From: [REDACTED]
Sent: 22 May 2017 09:52
To: Planning.Responses; Anita Gardner
Cc: Jacky Pendleton
Subject: Strategic Planning Response Re-consultation CM/7/17

SUBJECT: CM/7/17/PL - The Old Piggery, The Street, Climping, West Sussex, BN17 5RG

Change of use of permitted office building (B1 Business) to 4 No. visitor residential accommodation units (C1 Hotels). This application affects the setting of a Listed Building. Further information.

block plan 1:500@A1

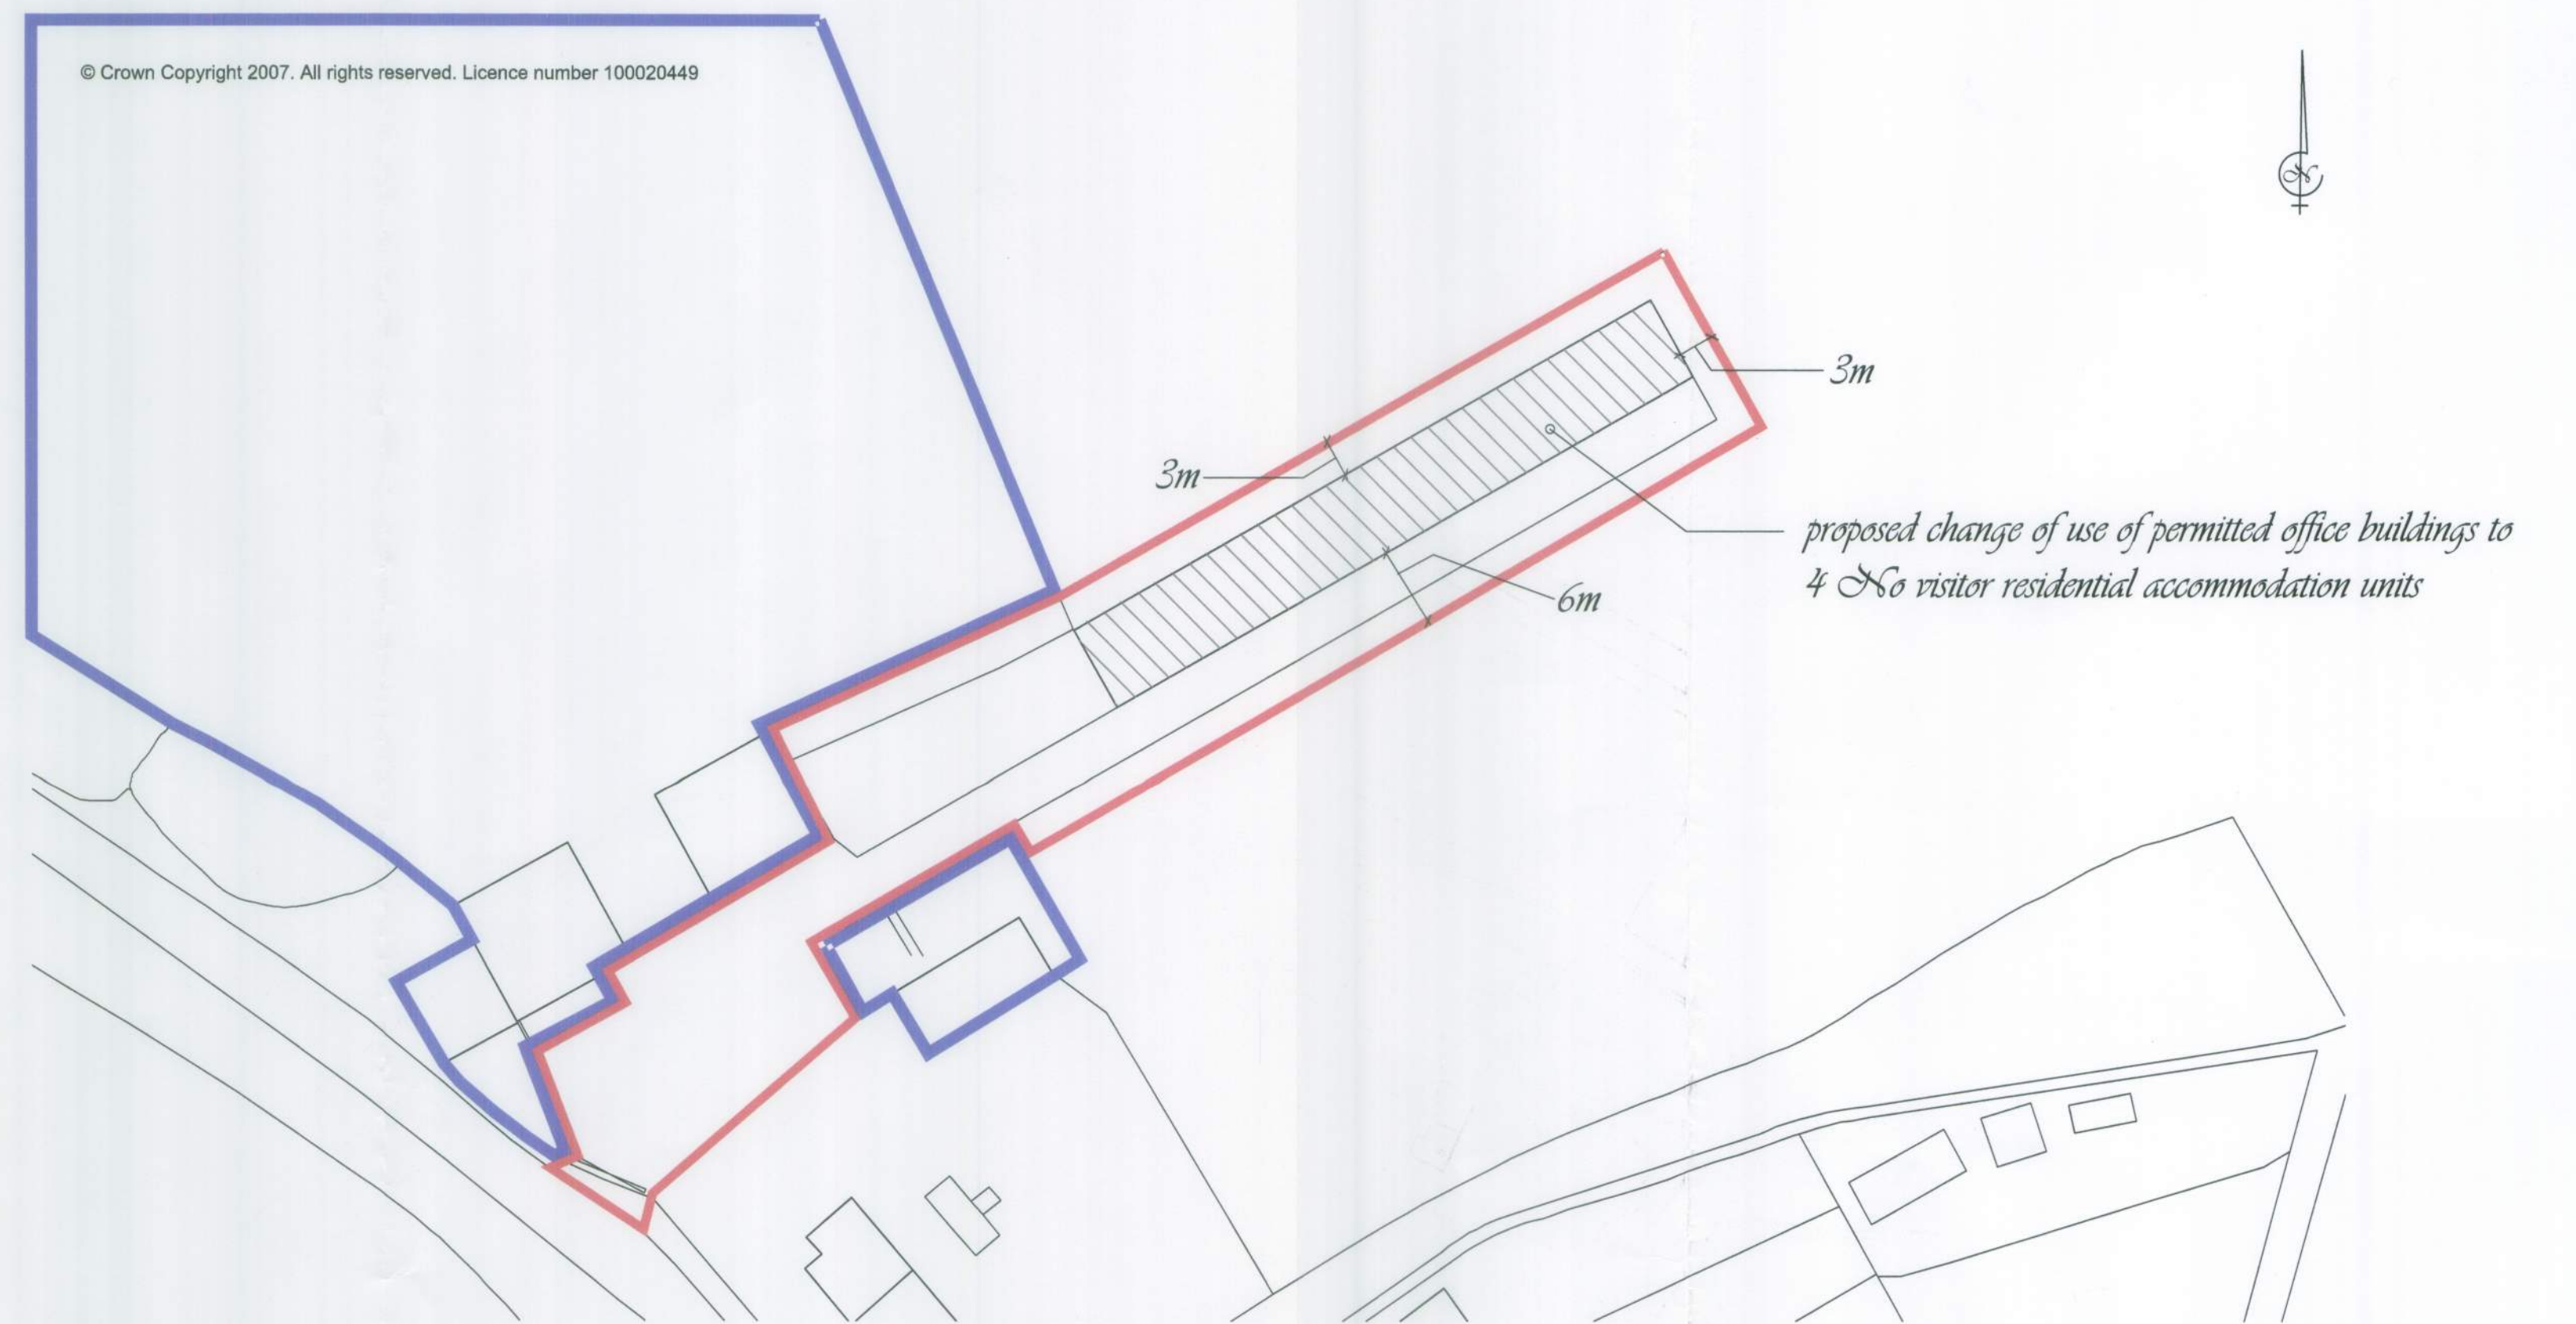
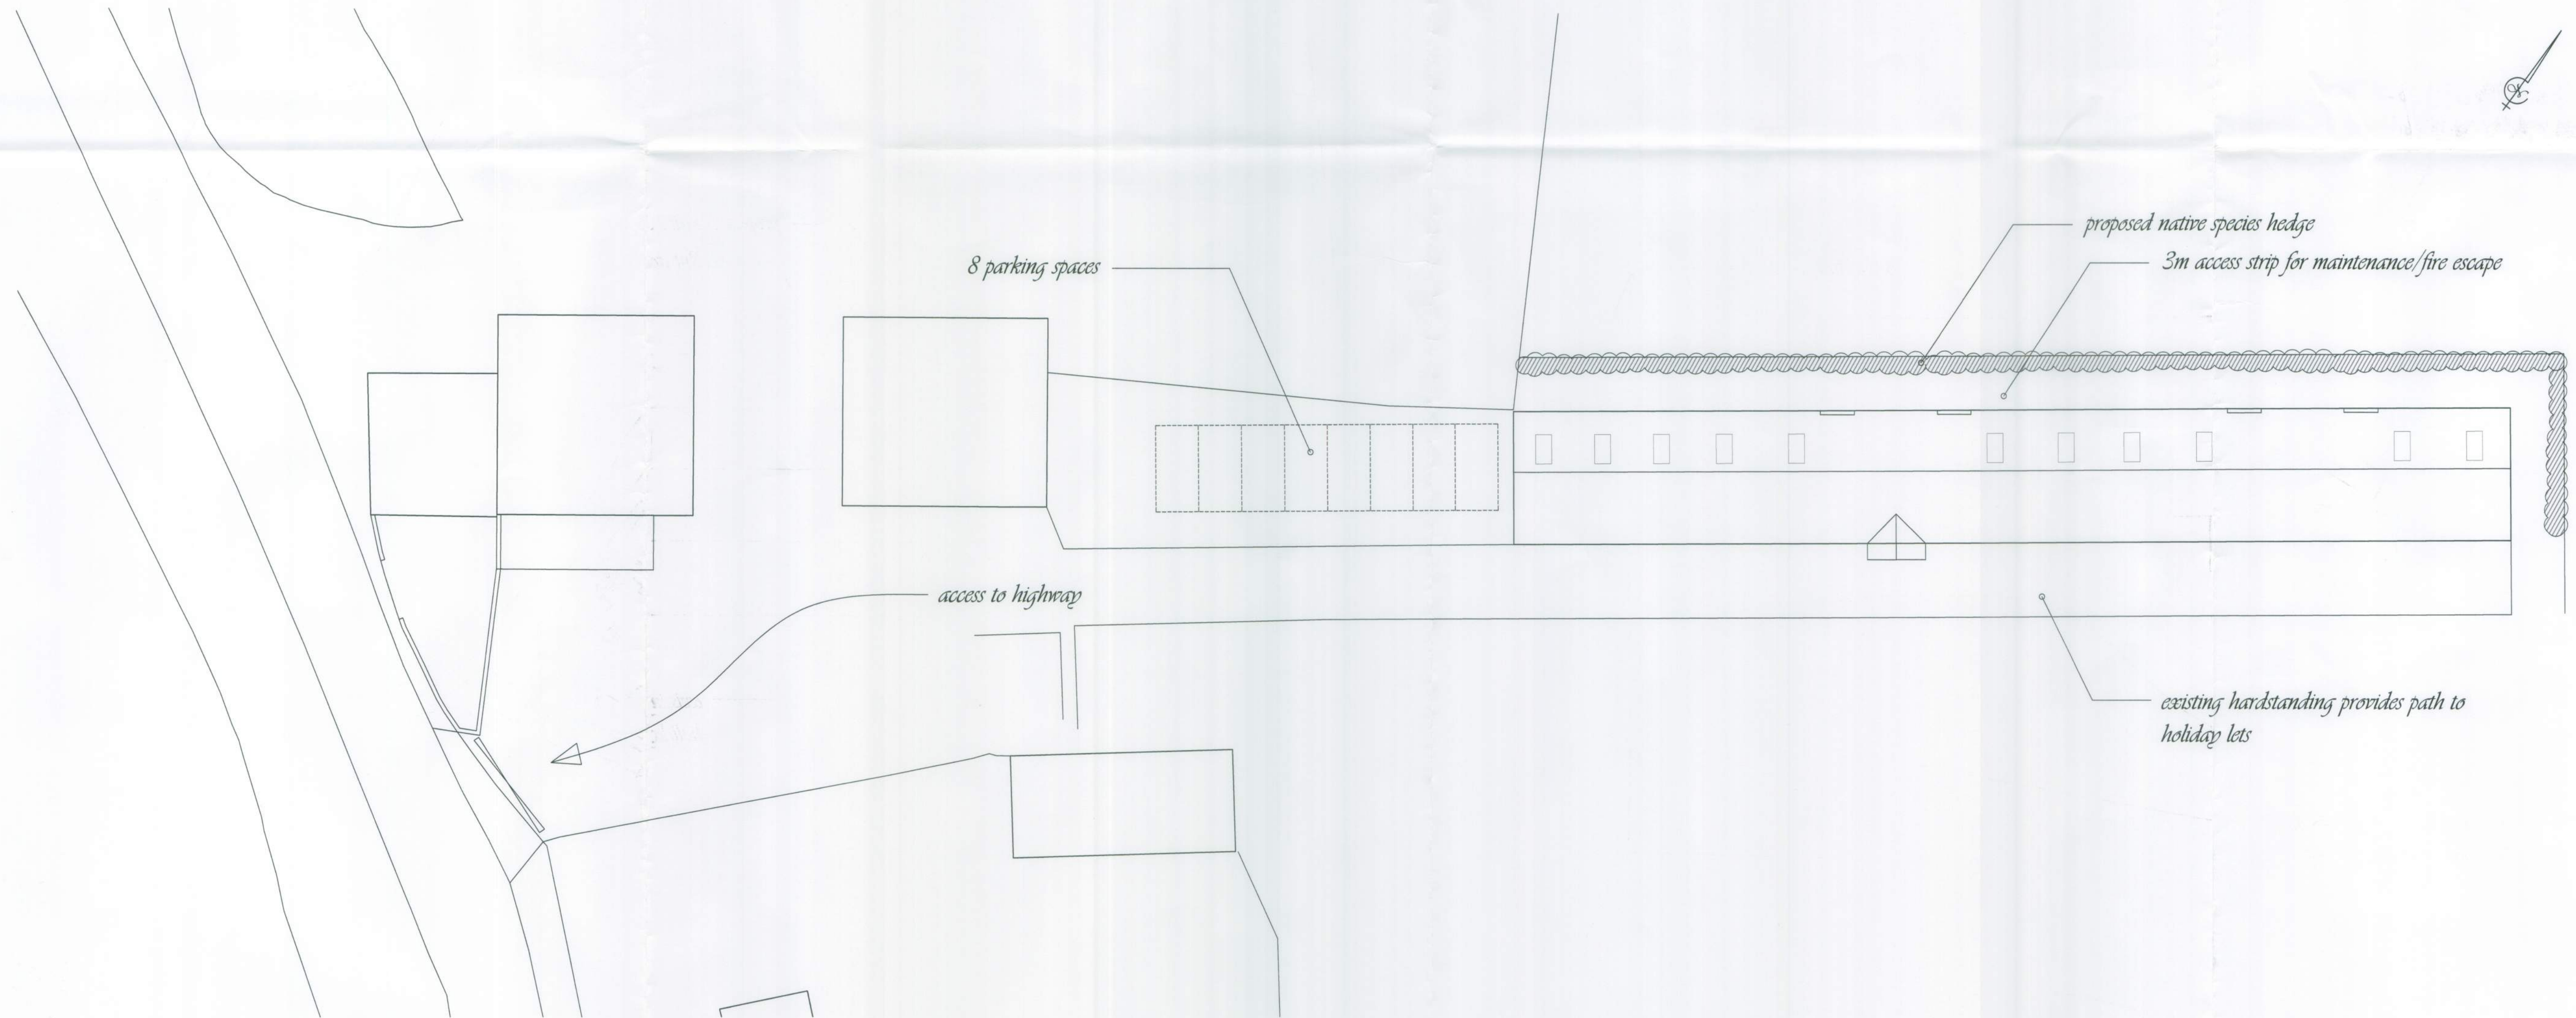
In our previous response we requested further information on vehicular visibility achievable from the existing access point and anticipated trip generation.

It has become clear that the applicant maintains and owns a small section of land to the north east of the access and that vegetation and lowering of the wall, as necessary to support a maximum achievable visibility splay, is possible. Maximum achievable visibility splays, from 2.4 metre back into the centre of the existing access, should be drawn to the nearside road edge in both directions. This can be carried out and secured under condition. The Local Planning Authority (LPA) should be aware that this will involve works to the wall and vegetation and may wish to consider this from a street-scene perspective.

No part of the development shall be first occupied until maximum visibility splays shall be provided at the site access onto The Street in accordance with a plan to be submitted to and approved by

the planning authority. These splays shall thereafter be kept clear of all obstructions to visibility above a height of 0.6 metre above the adjoining road level.

No development shall be first occupied until plans and details of the proposed gravel trap/ hardbound material to prevent gravel overspill onto the highway is submitted to and approved in writing by the Local Planning Authority.
